**Southern
Water**

Proposal: Outline planning application (with all matters reserved except for access) for the development of up to 1,500 dwellings (Use Class C3), 60-bed care home (Use Class C2), up to 9,000 sqm of employment floorspace (Use Classes B1), local centre of up to 2,350 sqm including up to 900 sqm retail / commercial (Use Classes A1-A5) and 1,450 sqm community / leisure floorspace (Use Classes D1-D2), land for a two-form entry primary school (Use Class D1), public open space, allotments, new sports pitches and associated facilities, drainage, parking and associated access, infrastructure, landscape, ancillary and site preparation works, including demolition of existing buildings and part removal of existing runway hardstanding. This application affects a Public Right of Way. This application is the subject of an Environmental Statement. This application falls within CIL Zone 1 - Zero Rated.

Site: F/4/20/OUT: - Land at Ford Airfield Ford, West Sussex BN18 0HY.

We write further to our letter dated 24/11/2021 and in response to the issuing of planning condition 35 for application F/4/20/OUT.

SCALE

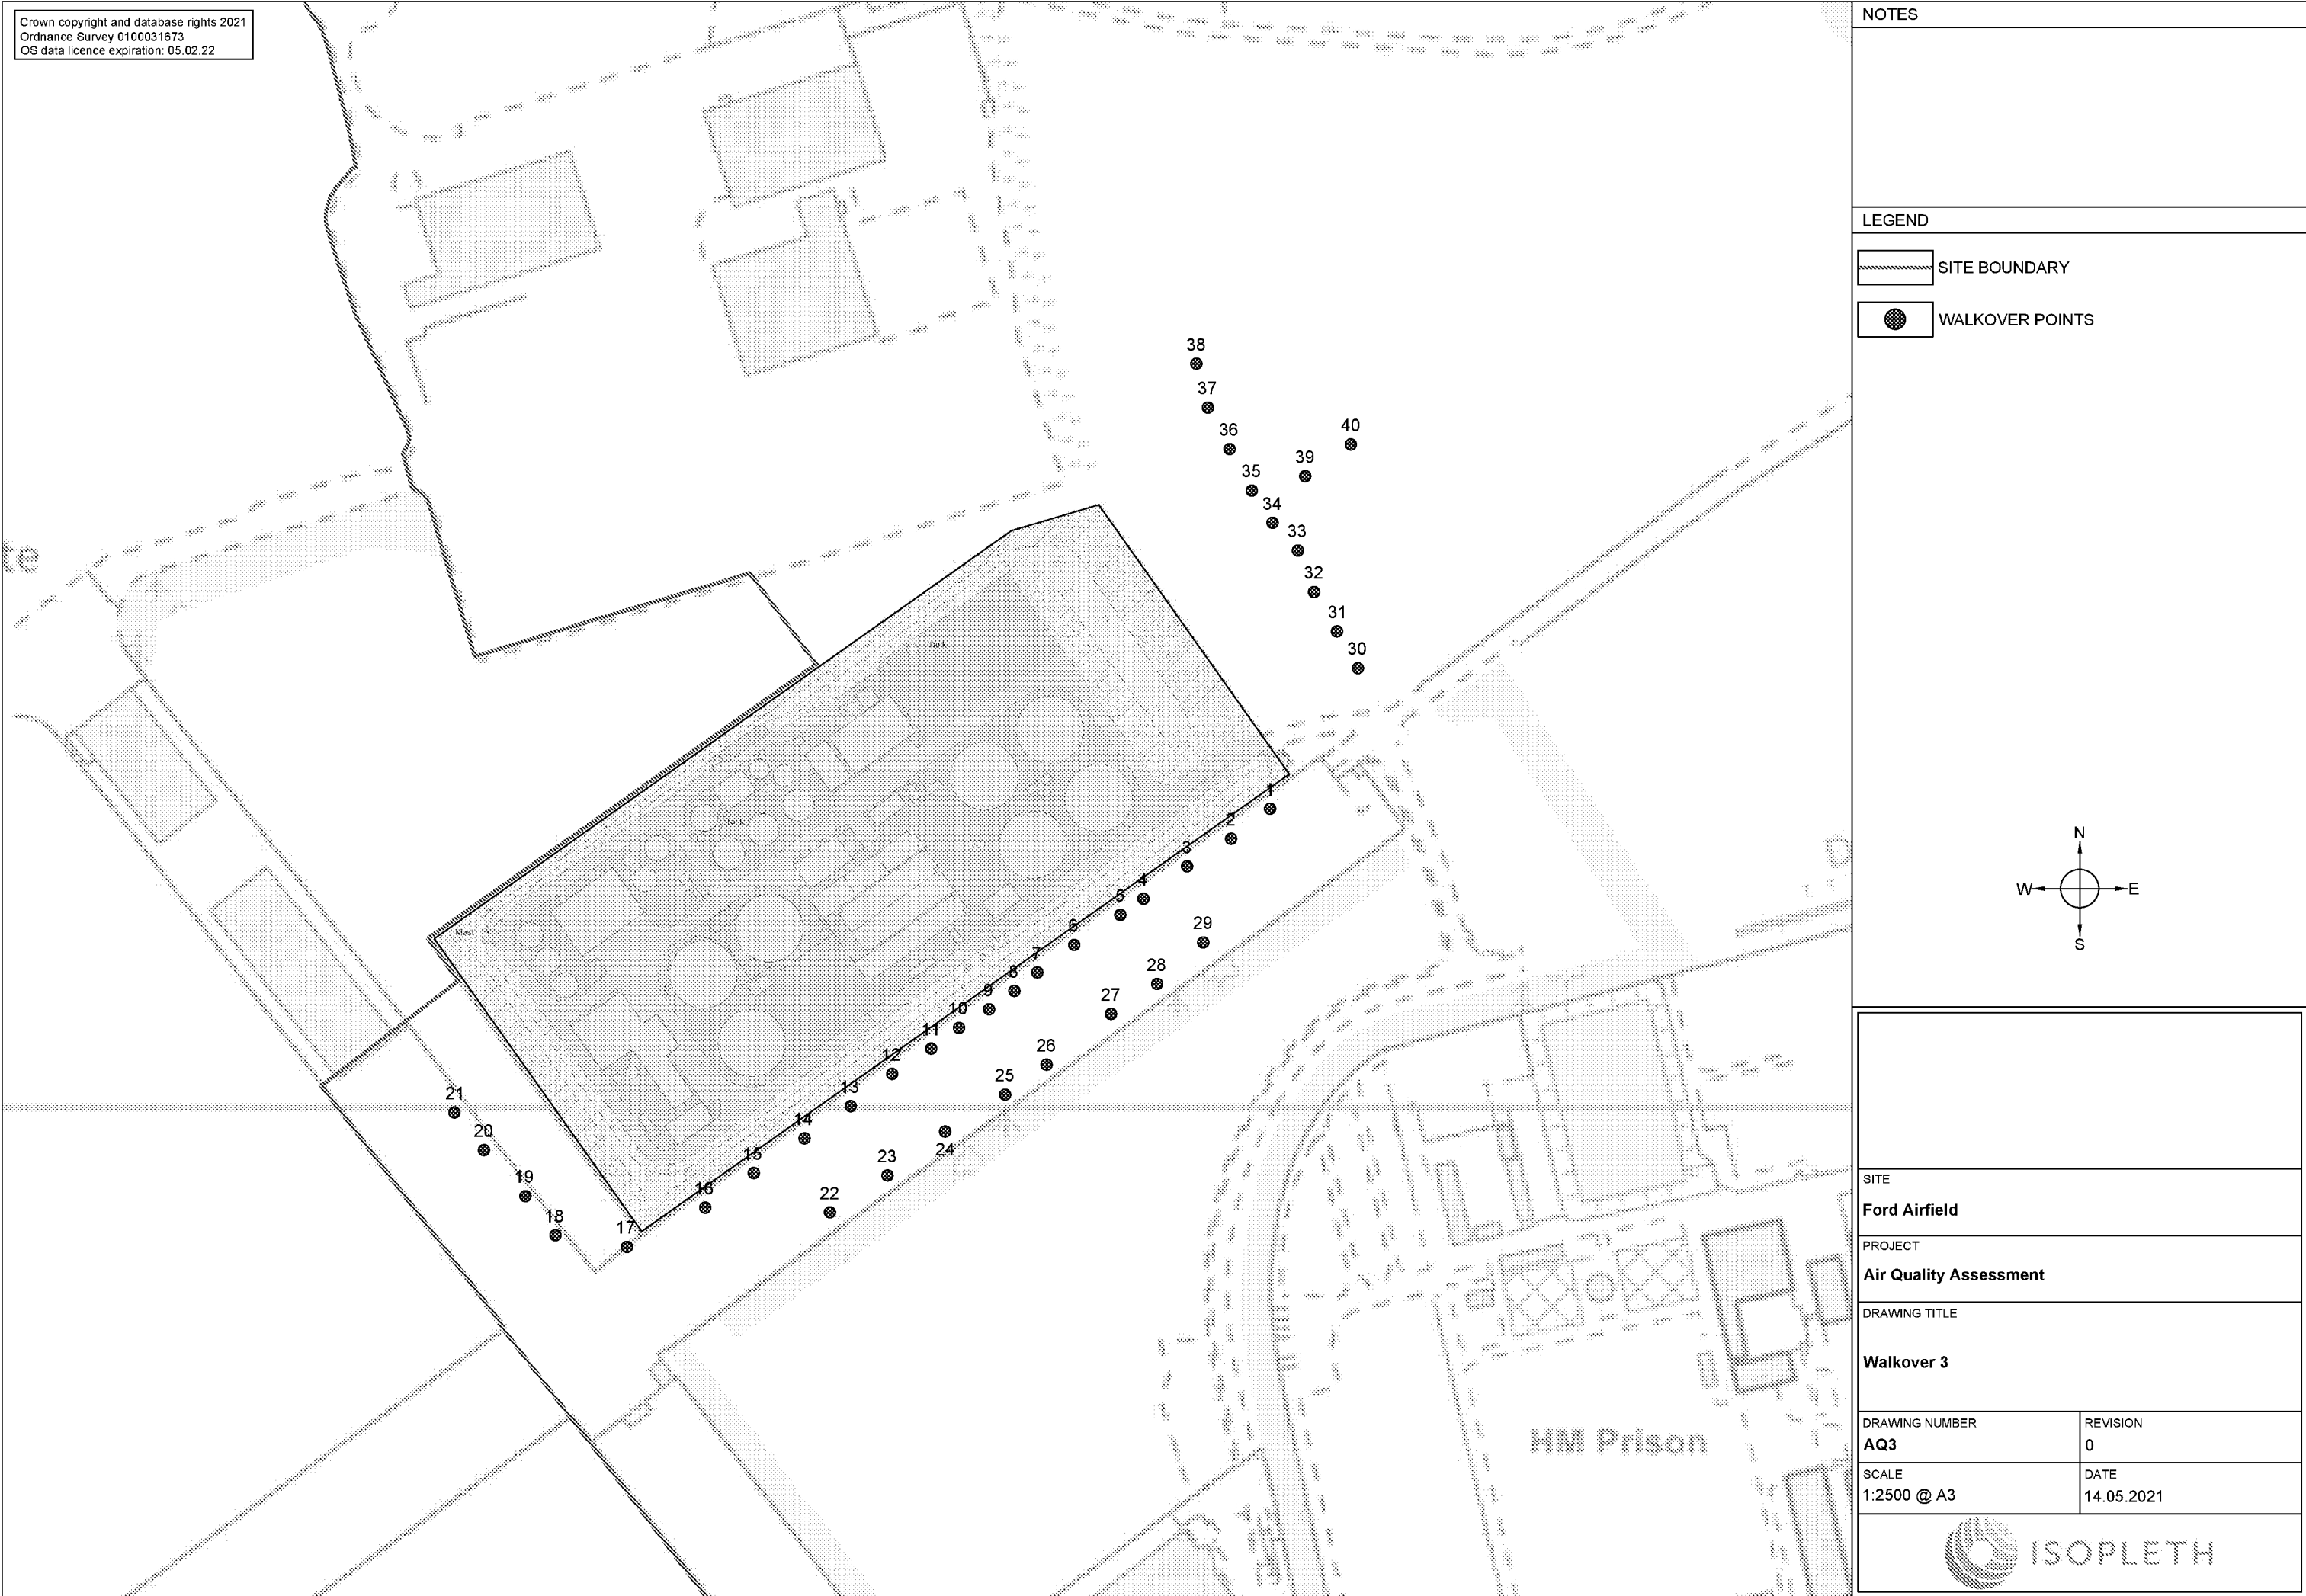
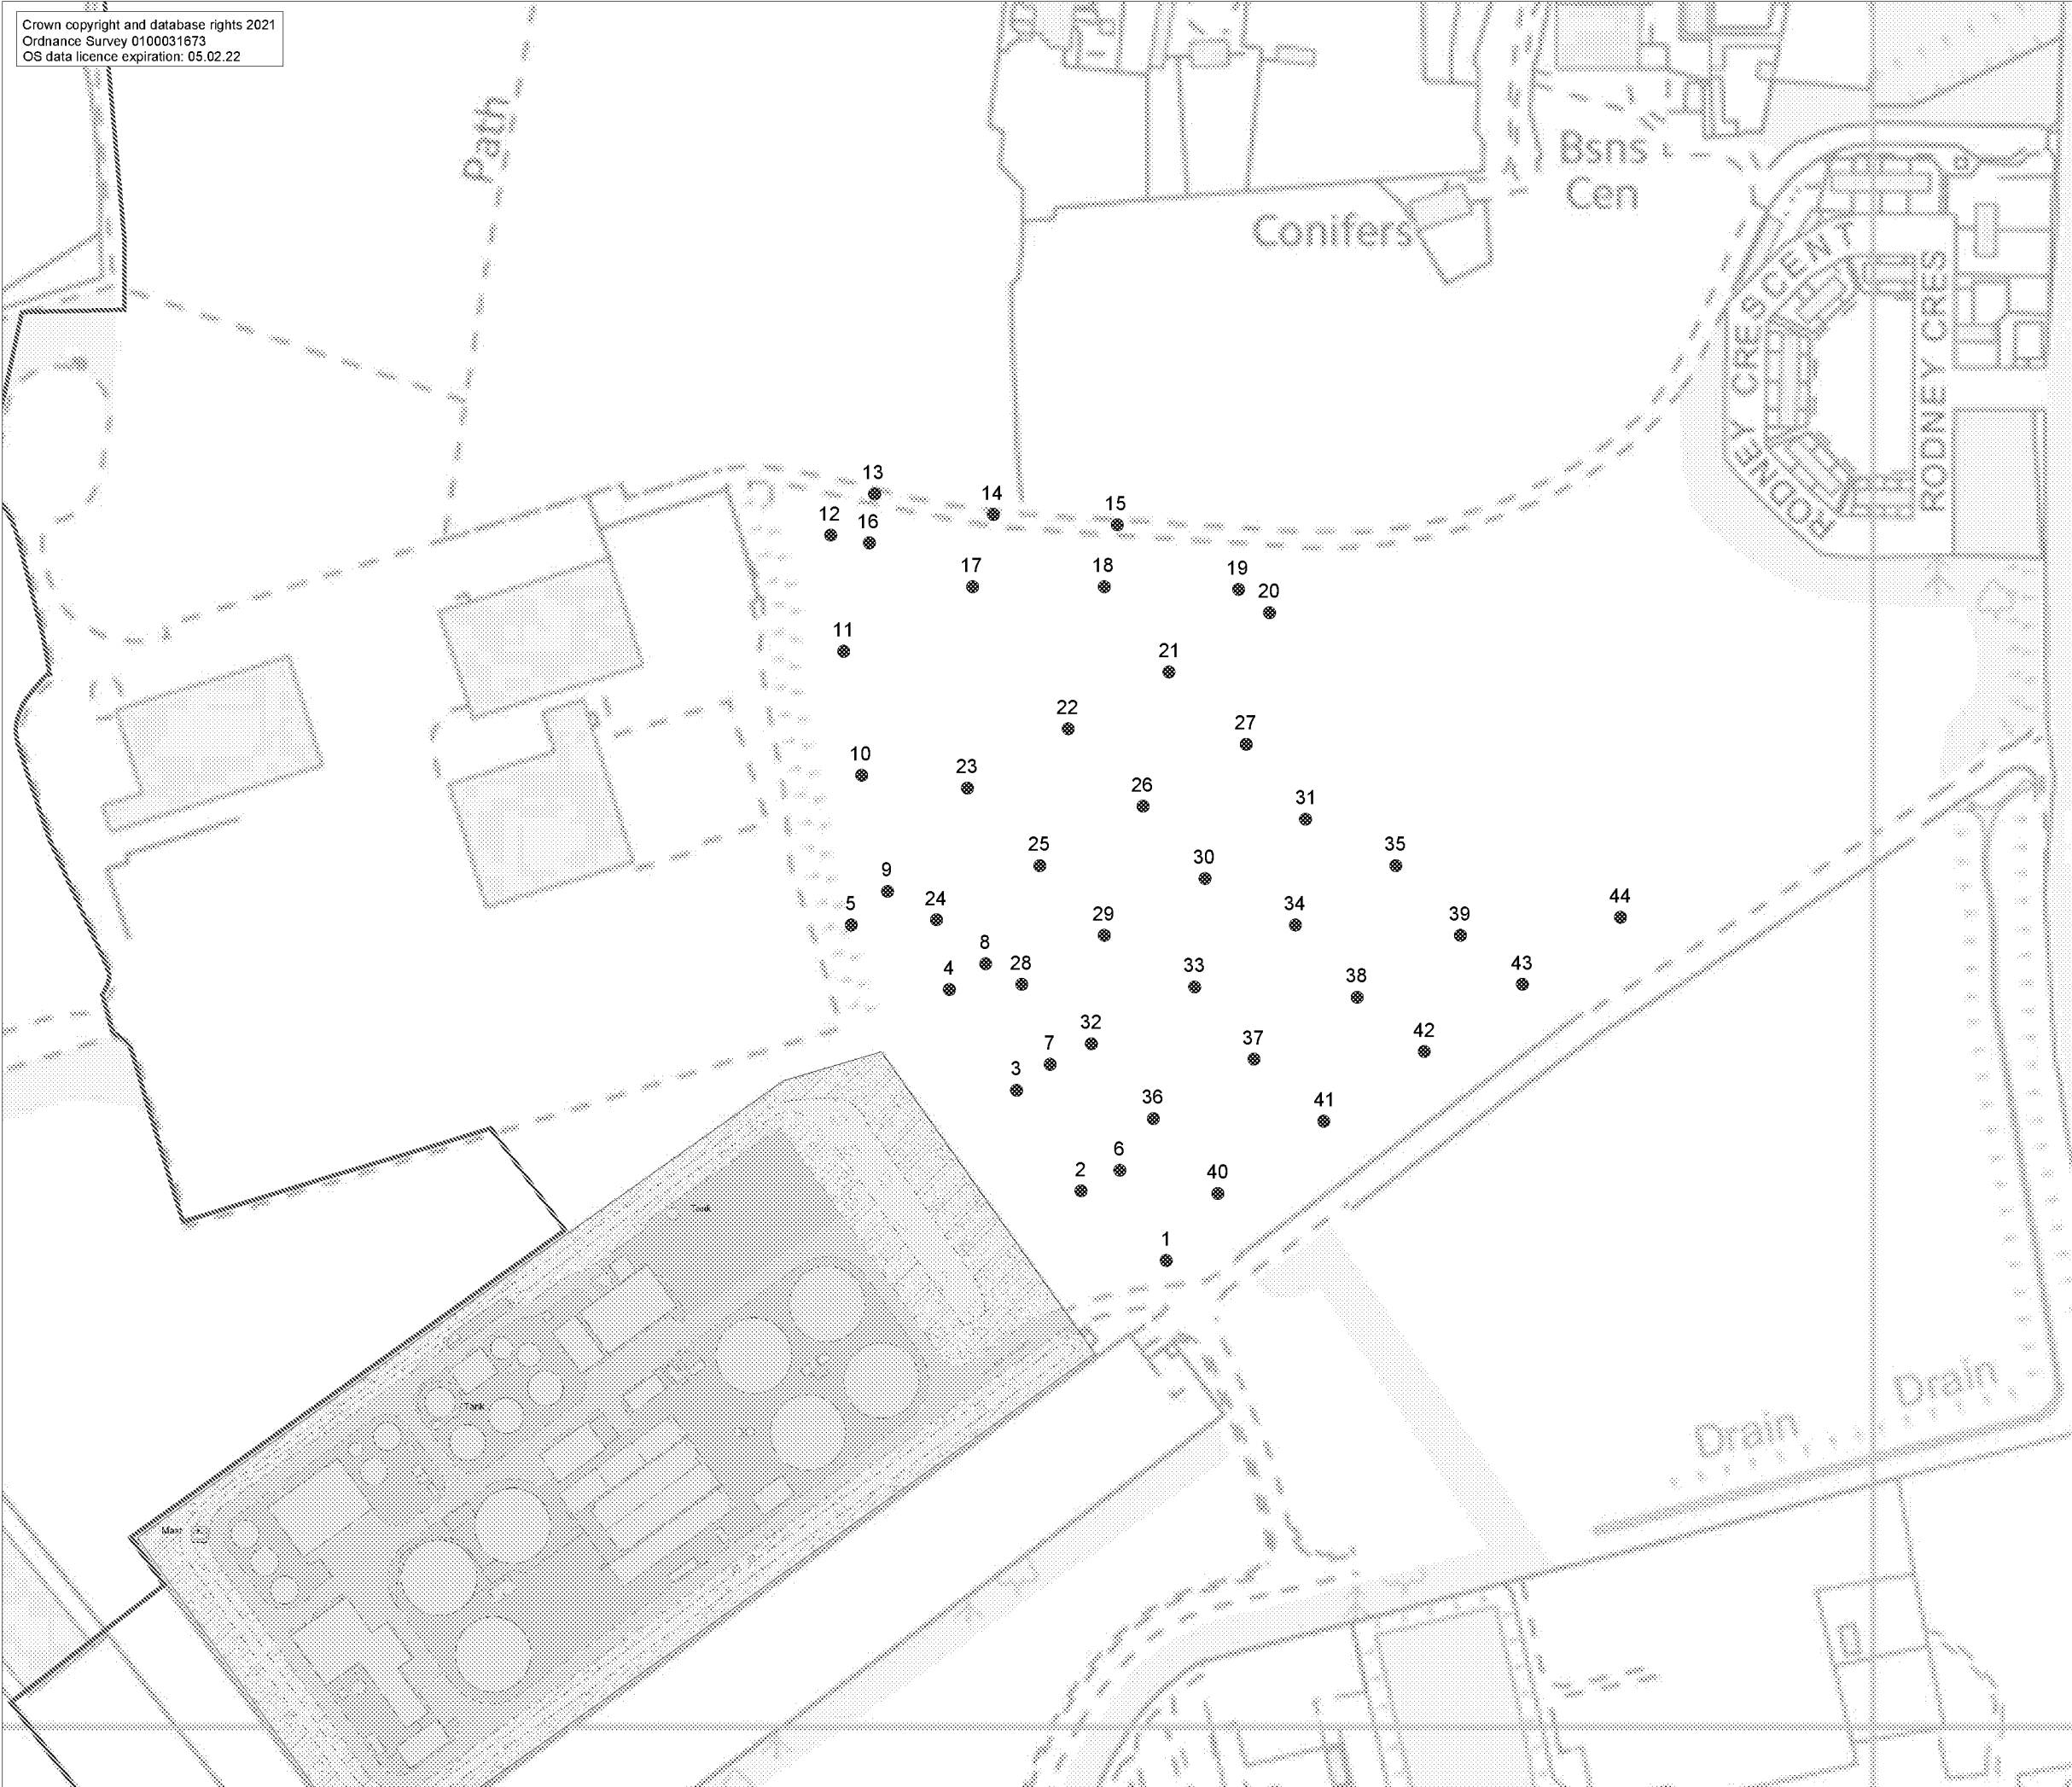
Condition 35 of the application, requesting a 300m buffer from the ASP, seems to be a misinterpretation of the advice provided by the Council's odour advisors.

The 300m buffer should be the area drawn from the ASP, Main OCU and Sludge OCU rather than just the ASP. The OCUs were identified as the 'most odorous part of the WwTW' and emissions from these areas, observed to be 'moderate' and significant, were detected at distances up to 300m in odour surveys.

Please can we receive a response advising as to why the buffer distances were applied only from the ASP and not the other 'main odour' sources identified by the assessment. Emissions from these sources were detected in excess of 300m from the source, noting the following quotes from the November 2021 Phlorum odour assessment review:

- "2.30 During walkover/sniff test 1, strong odours could be detected transiently but regularly up to 120m from the WwTW boundary, and at least 300m from the most odorous part of the WwTW, i.e., the main works odour control unit. The three locations where strong odours could be detected were not the three closest, as is suggested in the report, suggesting that a plume from the OCU might be grounding there".
- "2.4. Such discrepancy between modelled and observed results should point to the adoption of the precautionary principle. If unacceptable odour contours are predicted to occur 300m from sludge processes, then this ought to be considered the radius in all wind directions where such odours could affect the application site. This would be a more robust way to inform the appropriate layout of the masterplan."
